**KIRKLEES METROPOLITAN COUNCIL
INVESTMENT & REGENERATION SERVICE**

DELEGATED DECISION TO DETERMINE PLANNING APPLICATIONS

Reference No:	2025/62/90732/W
Site Address:	Parkwood Methodist Church, Parkwood Road, Longwood, Huddersfield, HD3 4TT
Description:	Erection of boundary fence (within a Conservation Area)
Recommending Officer:	Joanna Rednall

DECISION – CONDITIONAL FULL PERMISSION

SCALE	1:100	SHEET SIZE	A1
DRAWING NUMBER	0003 - ELEVATIONS	REVISION	PO1

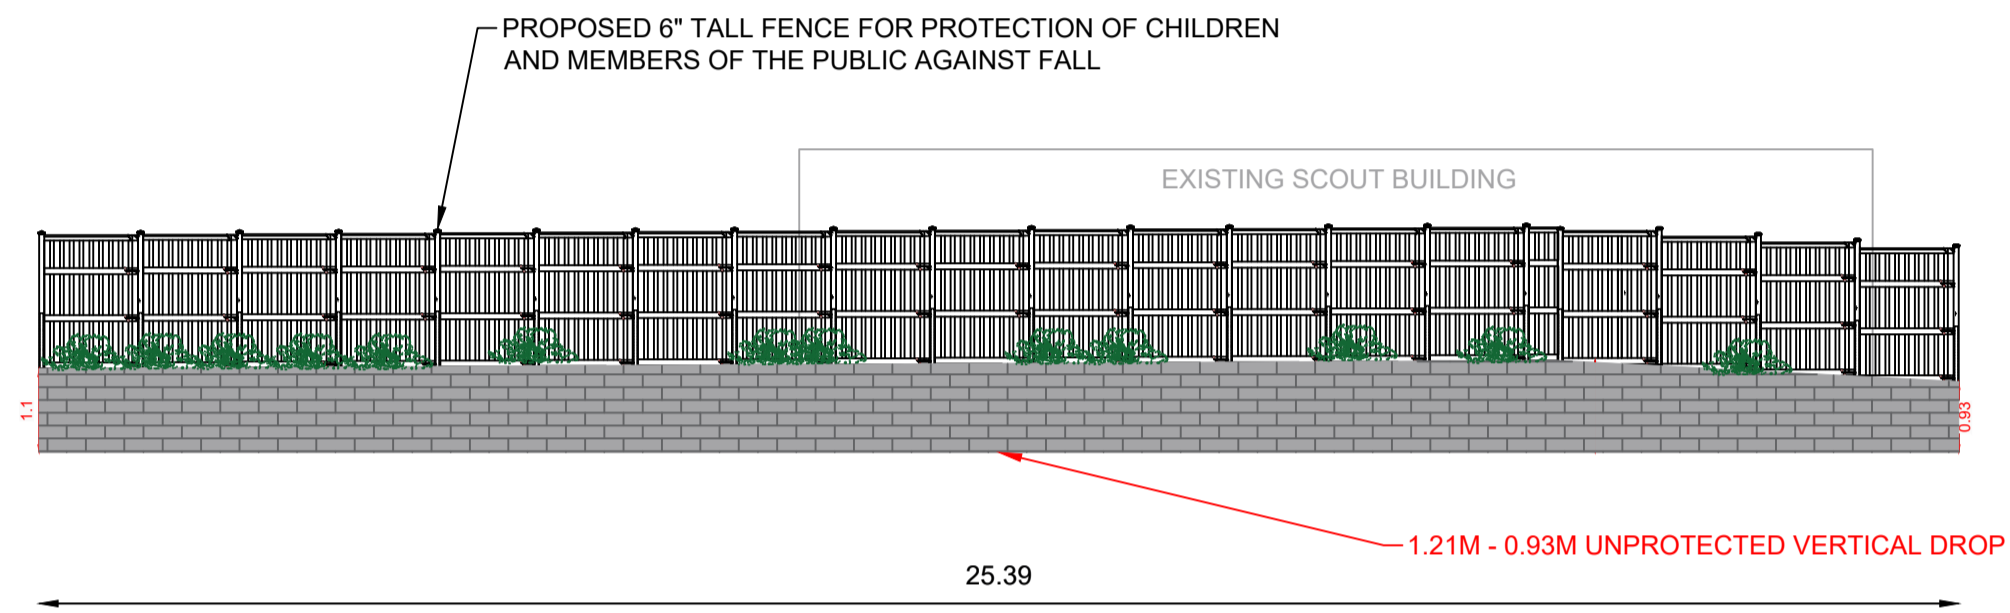
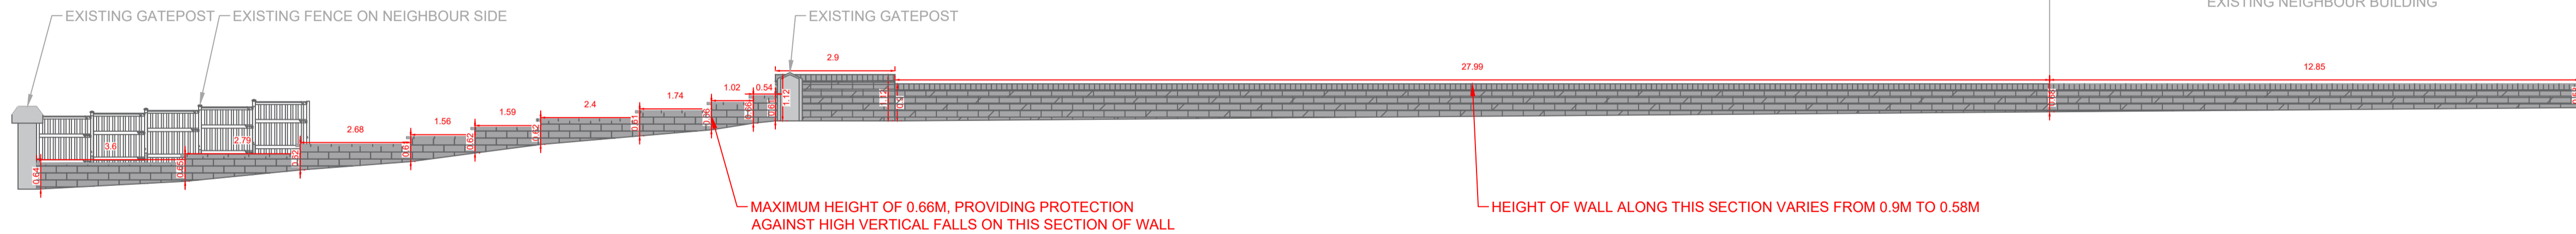
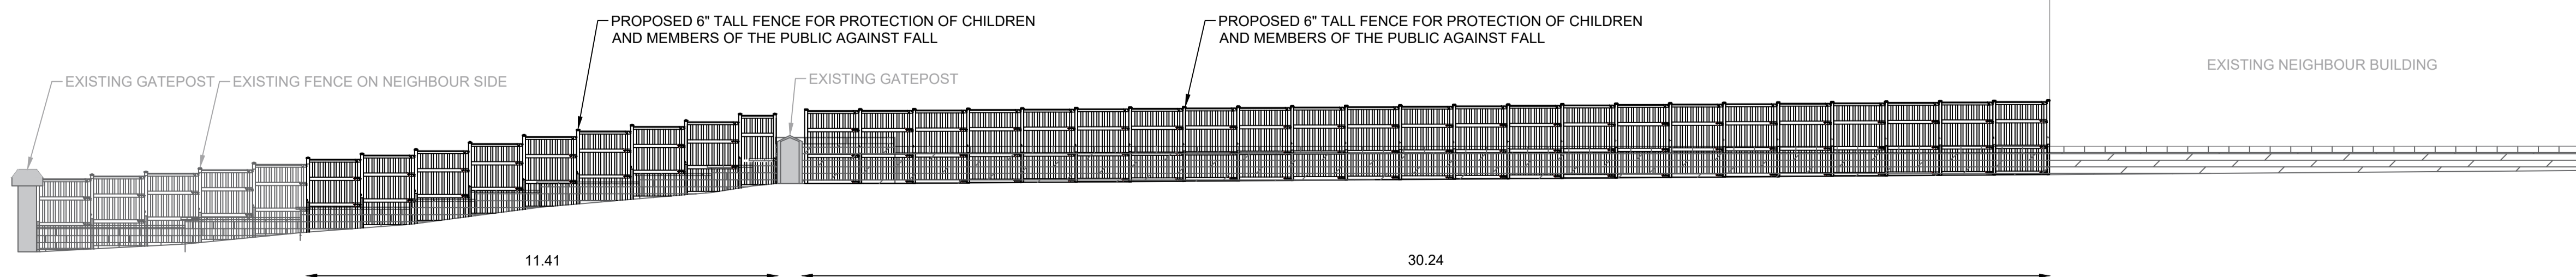
Amended plans were requested following discussions with KC Conservation and Design to reduce the fence height and alter its colour finish to be more in keeping with the Conservation Area. In response to the Conservation Officers' comments, the revised plans were submitted on 10th July. These amendments addressed the officers' concerns, and the application was progressed to determination on the basis of the updated scheme.

KC Conservation and Design: raised concerns regarding the height and colour finish of the fence with regard to its impact on the setting of the Conservation Area. The applicant submitted amended plans to address these concerns.

The scheme has been amended to address initial concerns and has seen a reduction in the height of the fence and also confirmation the fence shall be a dark green colour. Section 2 considers the impact of the fence in light of the heritage considerations as follows:

To ensure the proposal is undertaken as proposed, conditions would be imposed requiring the development to be in accordance with the amended plans submitted (0003RevP02) and that the fence is of a dark green colour finish.

3. The fence hereby approved shall be a dark green colour finish which shall thereafter be retained.
Reason: In the interests of visual amenity to accord with Policies LP24, LP35 & LP57 of the Kirklees Local Plan, and the aims of Chapters 2, 9, 12, 13 & 16 of the National Planning Policy Framework.
